Engineers Comments Regarding Surface Water Drainage

Application Reference:	BR/6/26/PL	Reviewer Reference:	ADC/EXT5/AF
Planning Officer:	Amber Willard	Date of Review:	20/02/2026
Site Name:	67, 69 and 71 Upper Bognor Road Bognor Regis PO21 1HR		
Application Description:	Retention of alterations to 3 No listed buildings, extension of a listed building to create an office and warden's accommodation, erection of 1 No new building consisting of 3 No flats, offices and workshops, creation of new private gardens, separation of this part of the site from the wider University campus, creation of a shared landscaped courtyard, areas for parking, and storage for bins and cycles. This application of listed buildings, affects the character and appearance of the Upper Bognor Road and Mead Lane Conservation Area and is in CIL Zone 4 (Zero Rated) as flats.		
Assessment Number:	1

Tree Protection Plan BJH 03/04

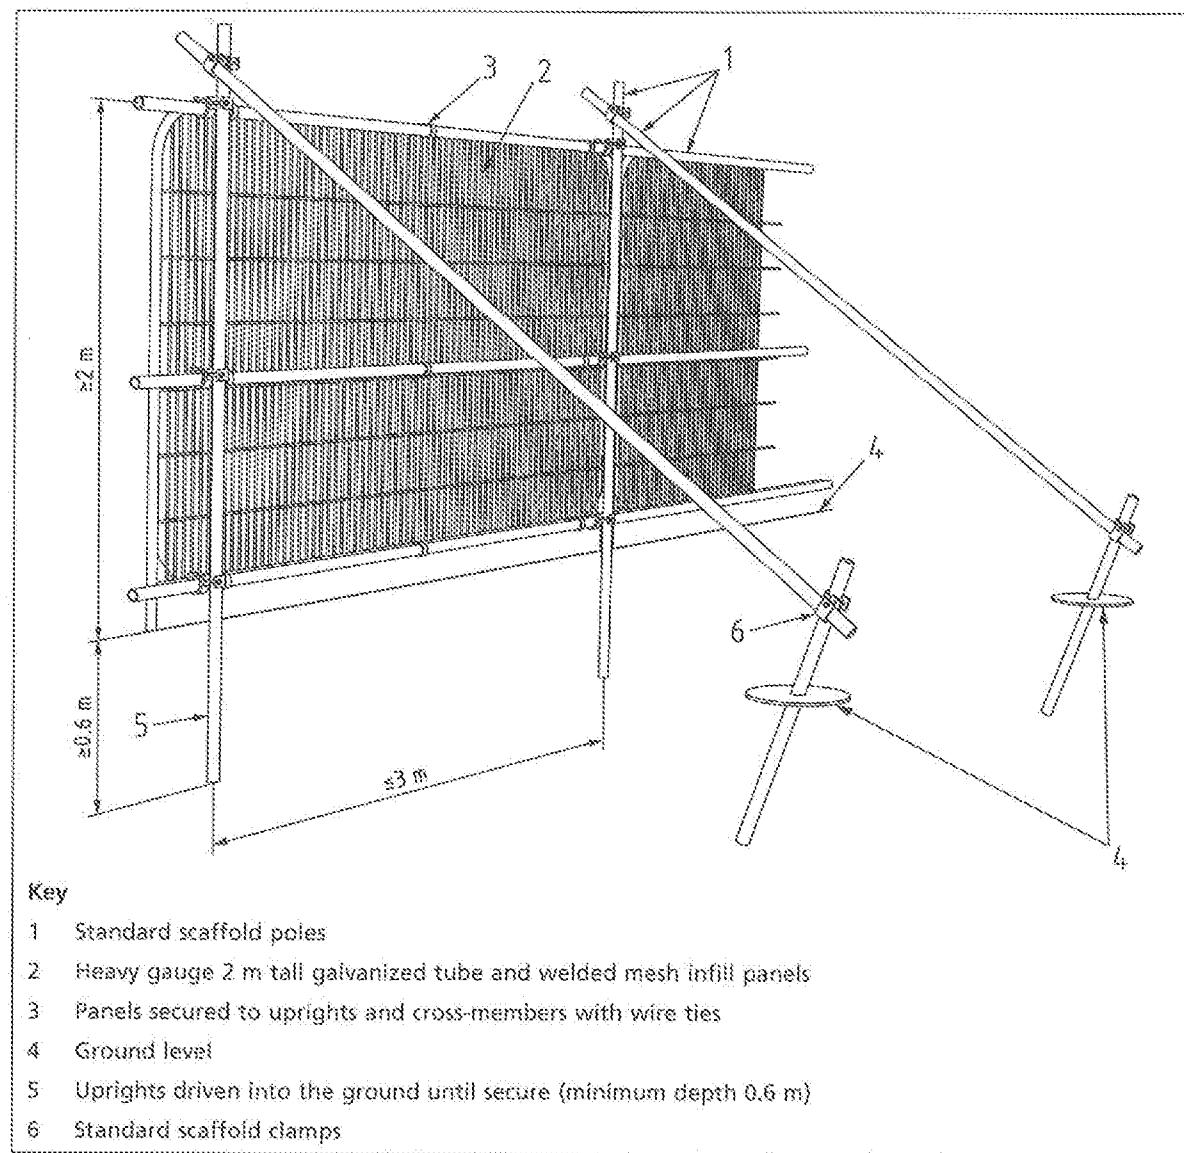
- 3.5. The extent of the permeable paved car park conflicts with the Root Protection Zones.
- 3.6. The calculations include permeable paving which attenuates design storm runoff. Detailed finished levels design is required to assess the gradients and depths of the stone layer to ensure correlation with the calculations.
